Notice of incompleteness #2, 7833 SE 28th St--revised
Project # DSR21-012

Per the comment letter dated November 12, 2021, below is the response to this comment letter along with the revised and updated plan set.

The City of Mercer Island received the above referenced application for Design Commission Design Review for the property located at 7833 SE 28th St (King County parcel # 545230-0380) on October 23, 2020. The city has assigned file number DSR21-012 to the application. Following review of the recent resubmittal on November 2, 2021, City staff has determined that the application is **incomplete**. Please provide the following items:

2 E STREET TREE SILVA CELL
1/2" = 1'-0"

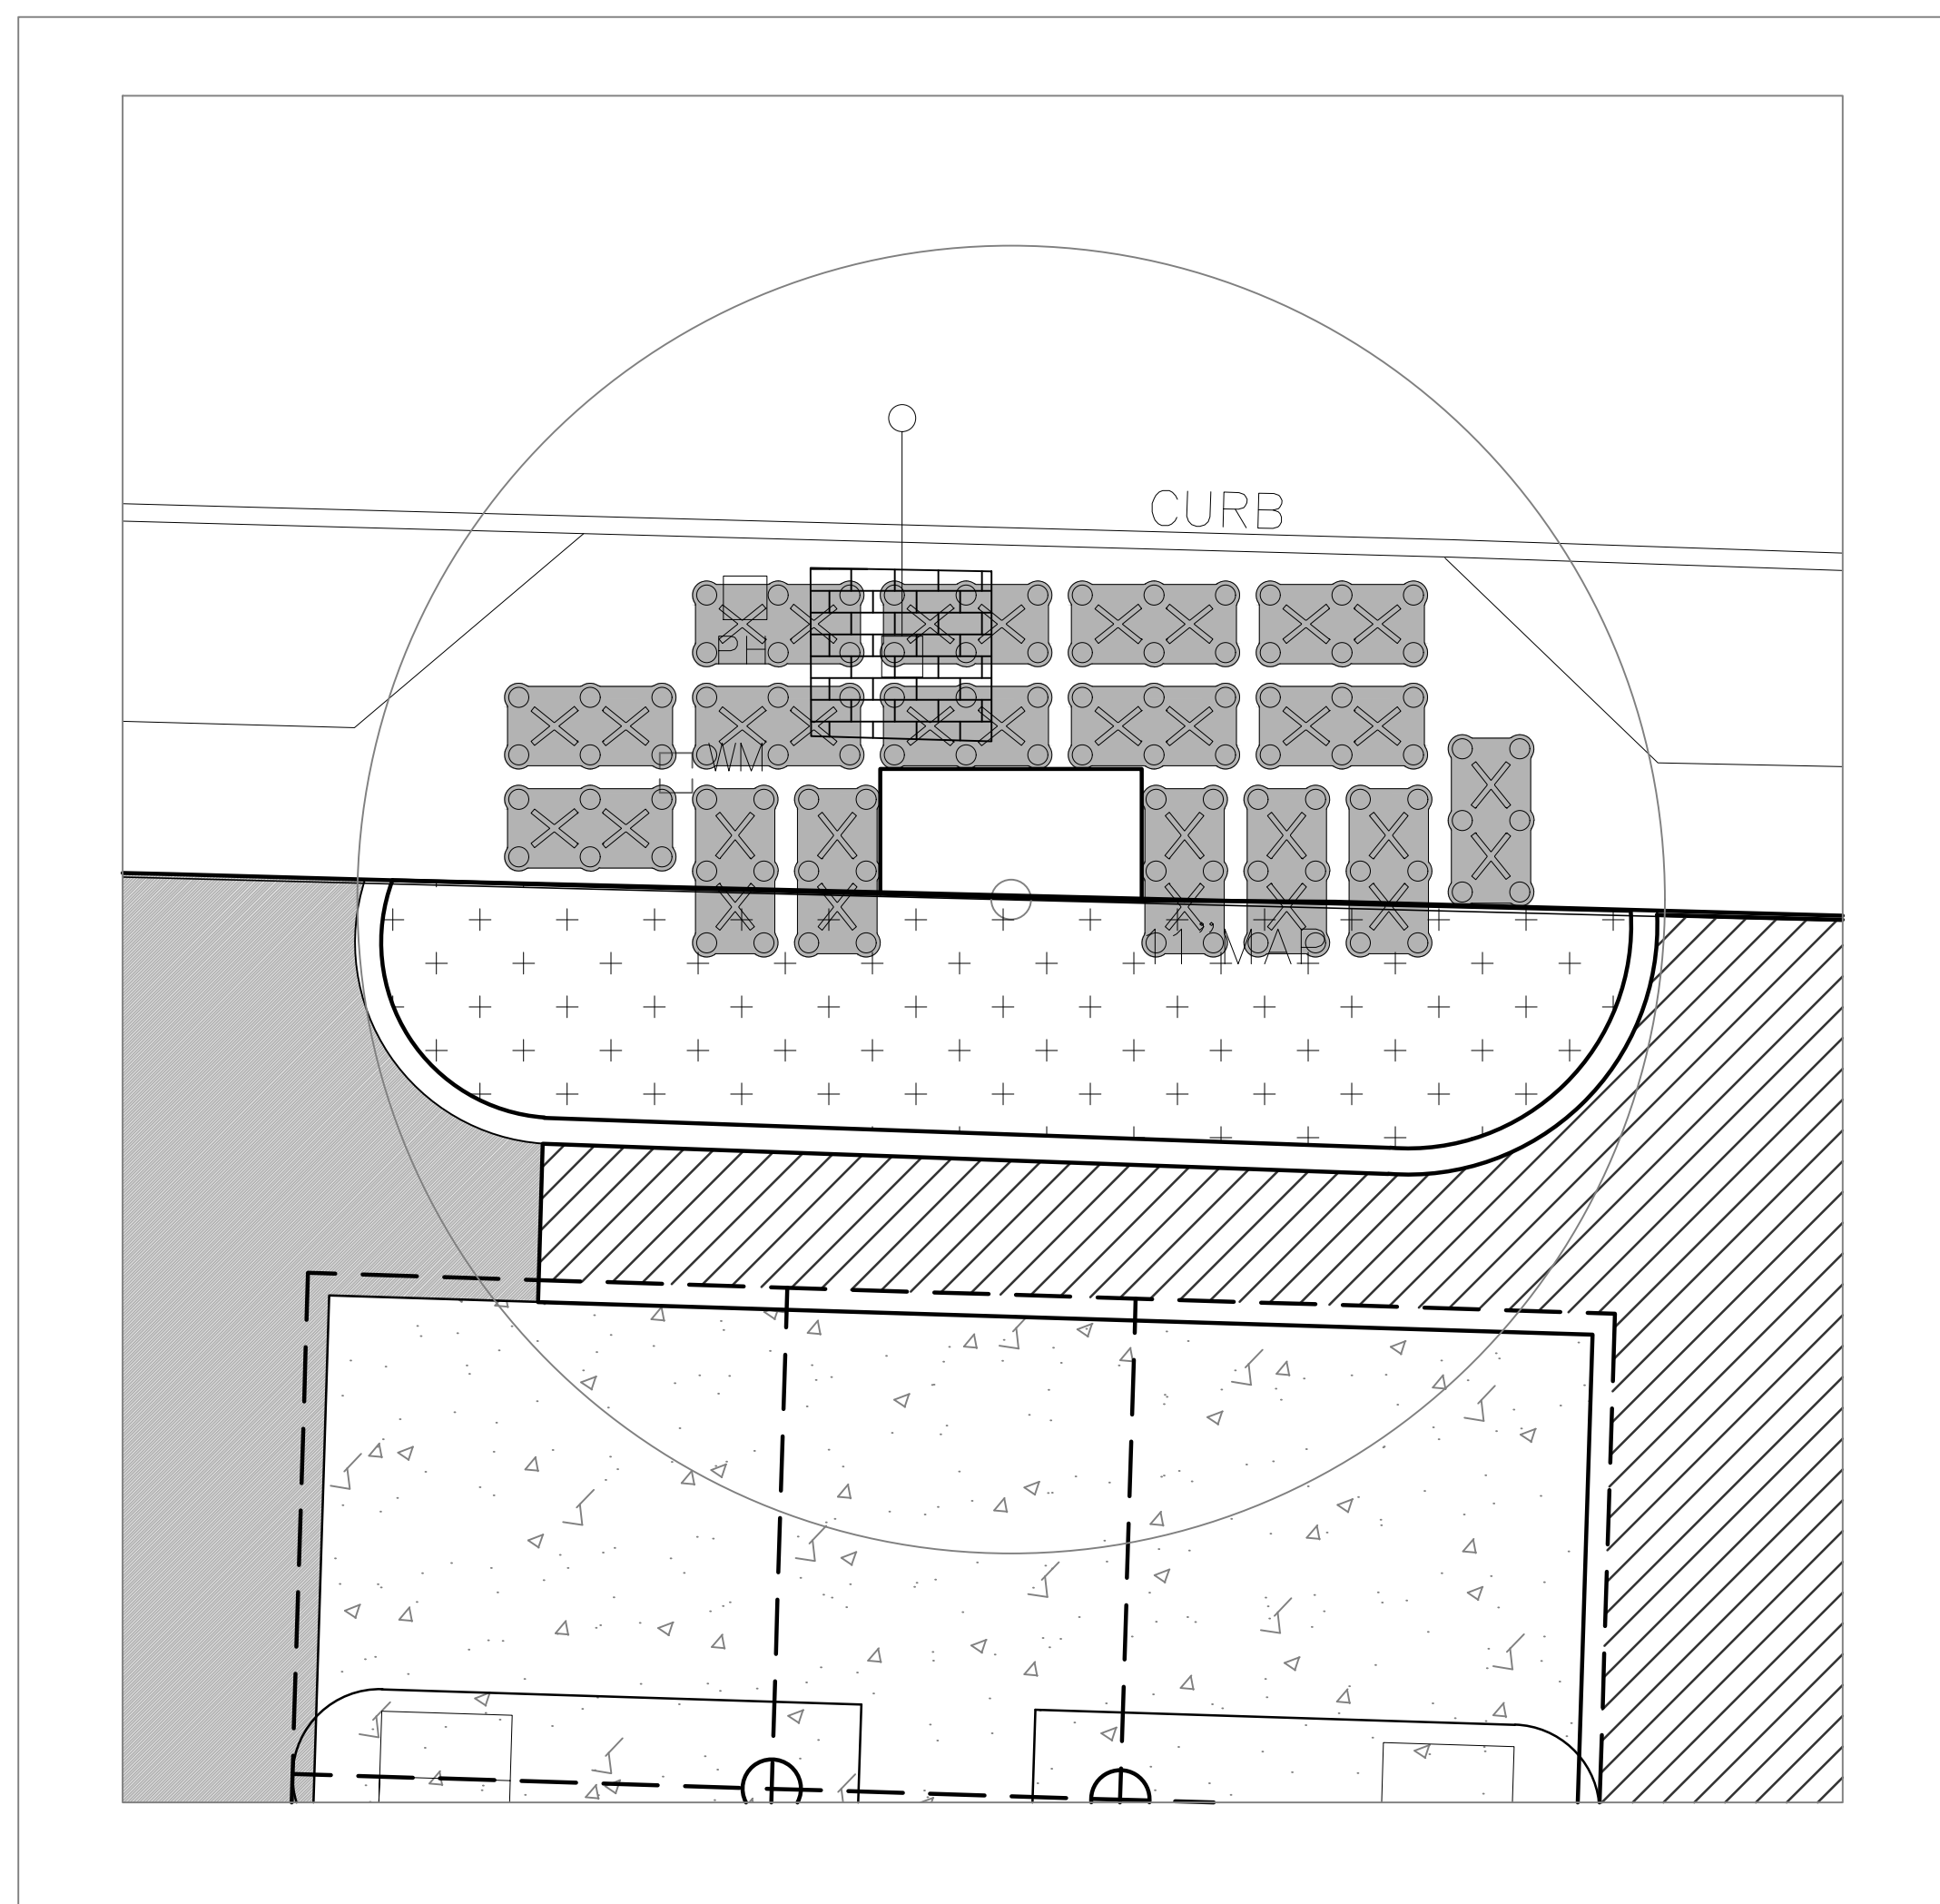
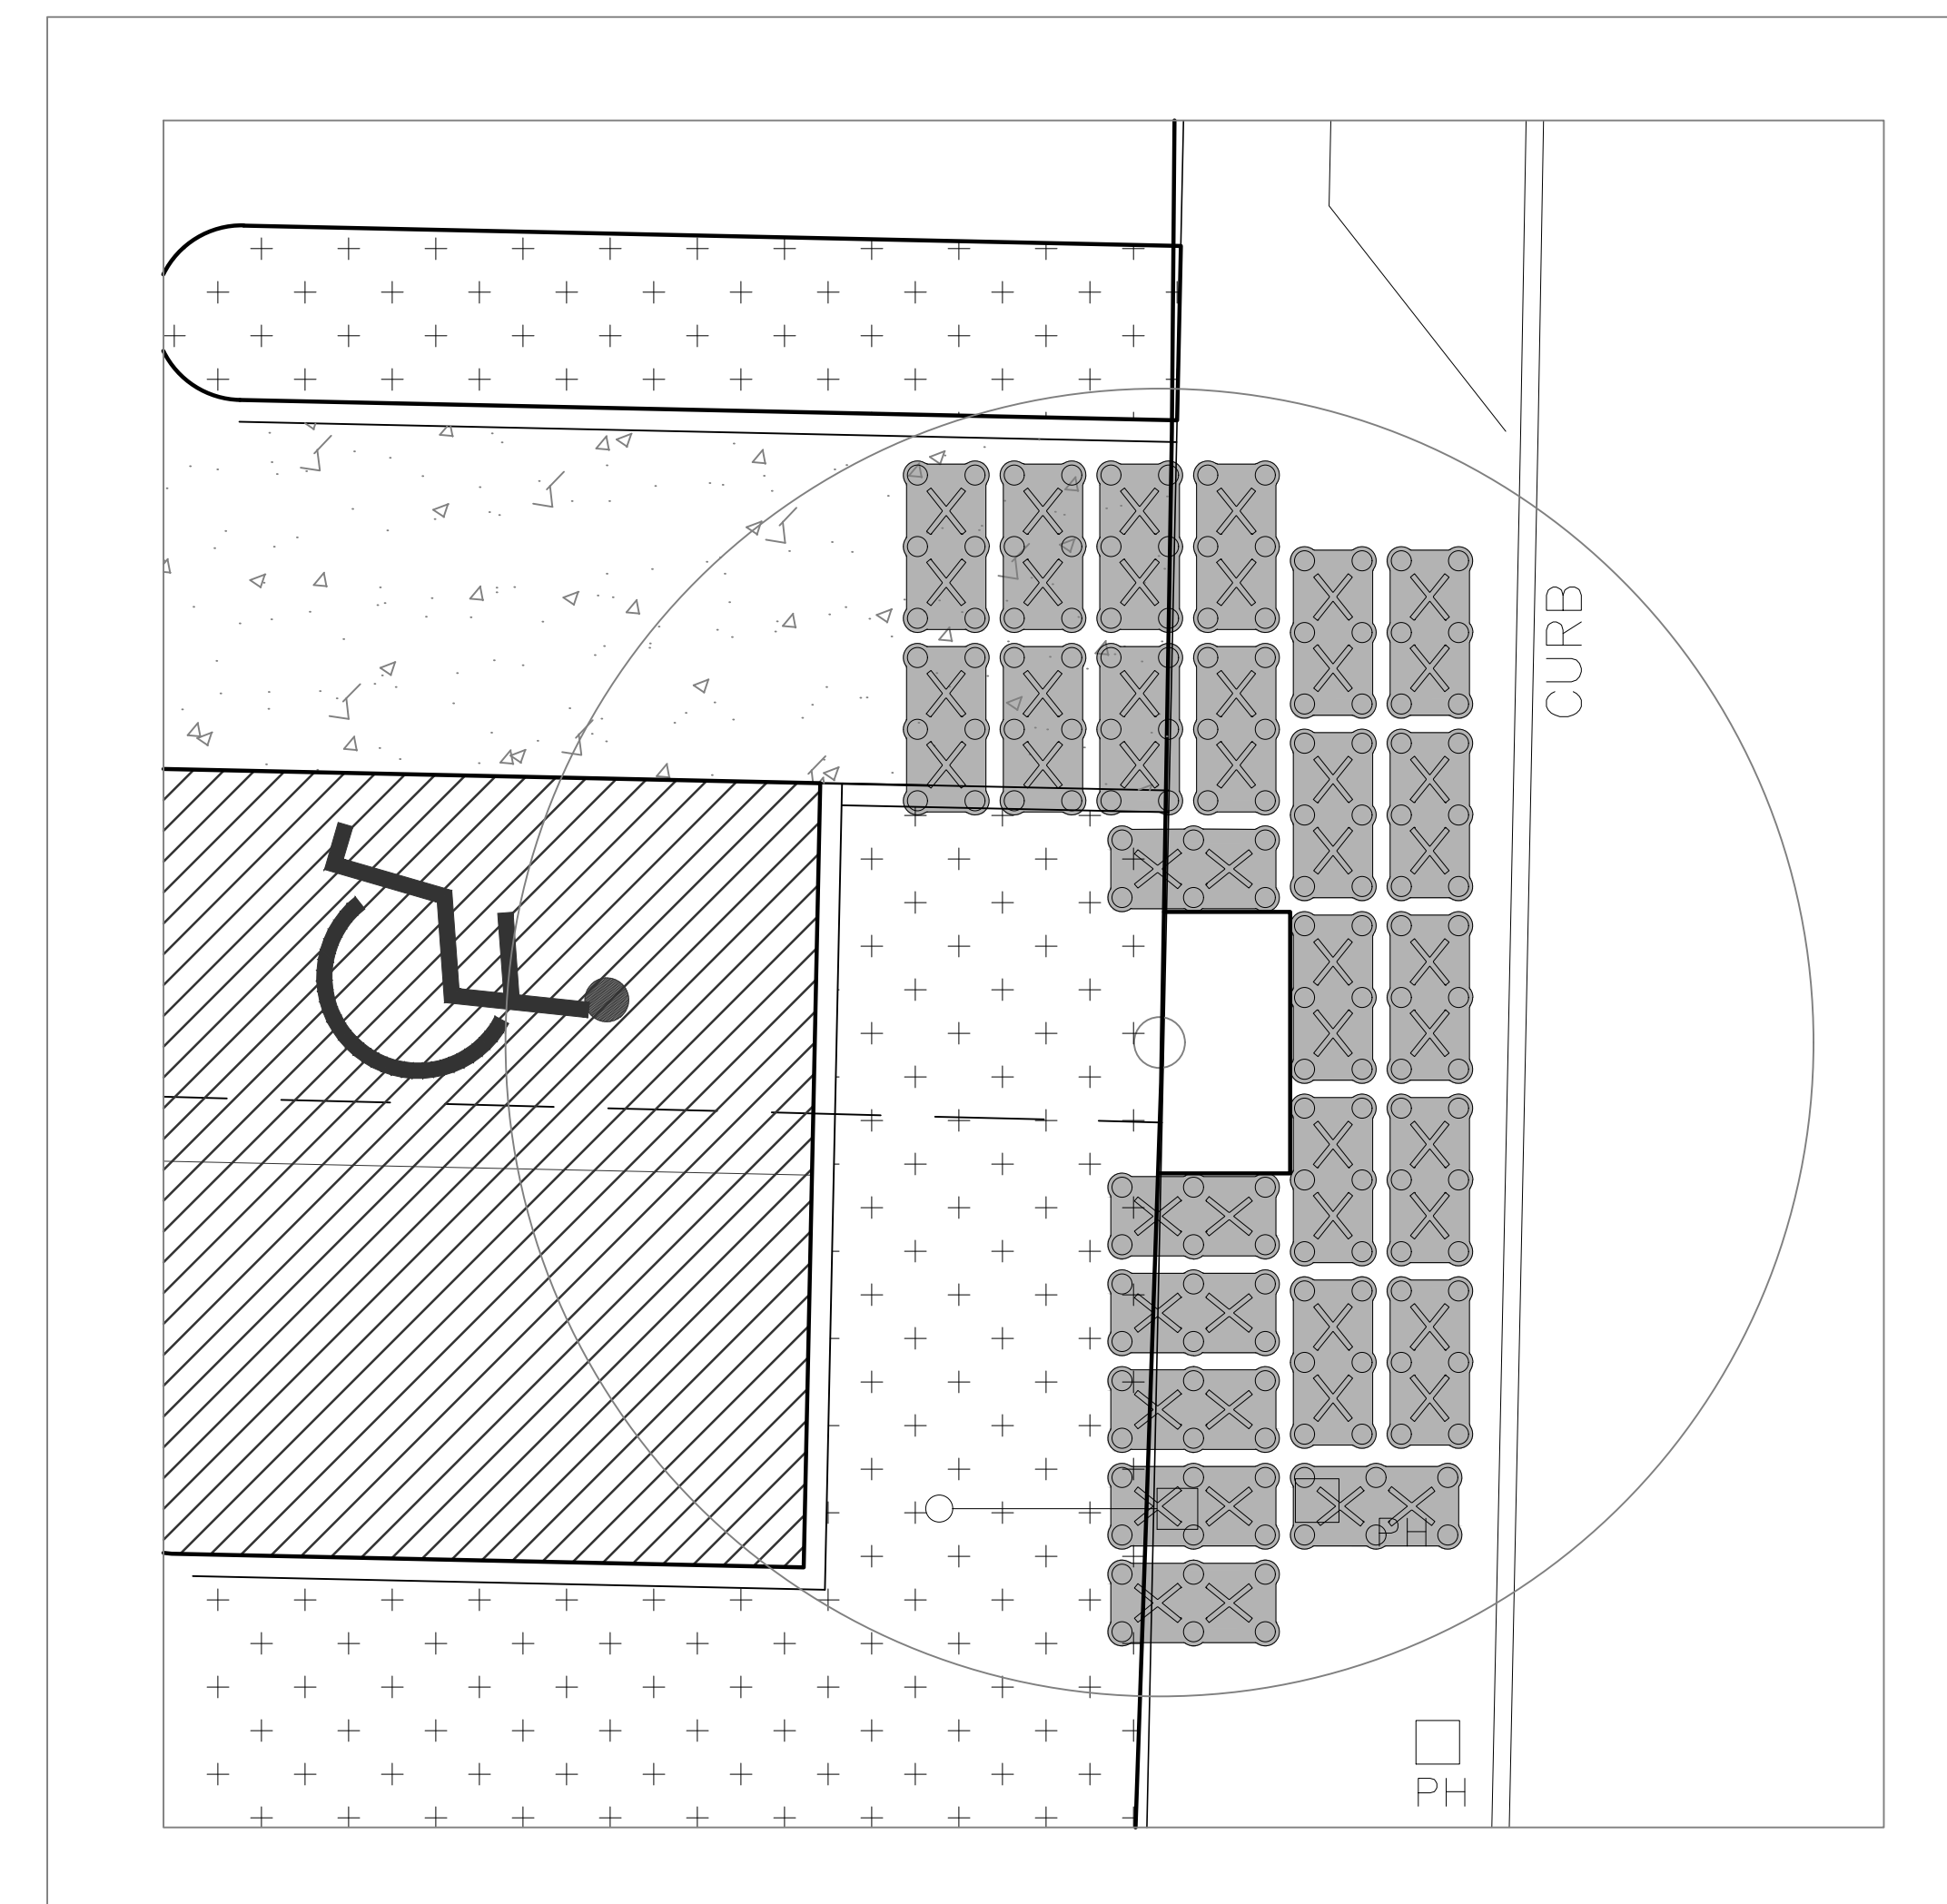
1. The extent of the proposed excavation is now shown to the property line. This would imply the trees do need to be removed. Since city trees are proposed for removal, at least 500 cubic feet of soil below suspended pavement technology of Silva Cell or equivalent will be required. This is according to The Mercer Island Town Center Draft Street Scape Manual page 4. This plan must also include irrigation for the trees. Once we confirm the soil volume, the city will inform you of the tree replacement species required.

RE: Landscape plans have been updated new sheet L3 has been updated to show silva cell as required per the city of Mercer Island.
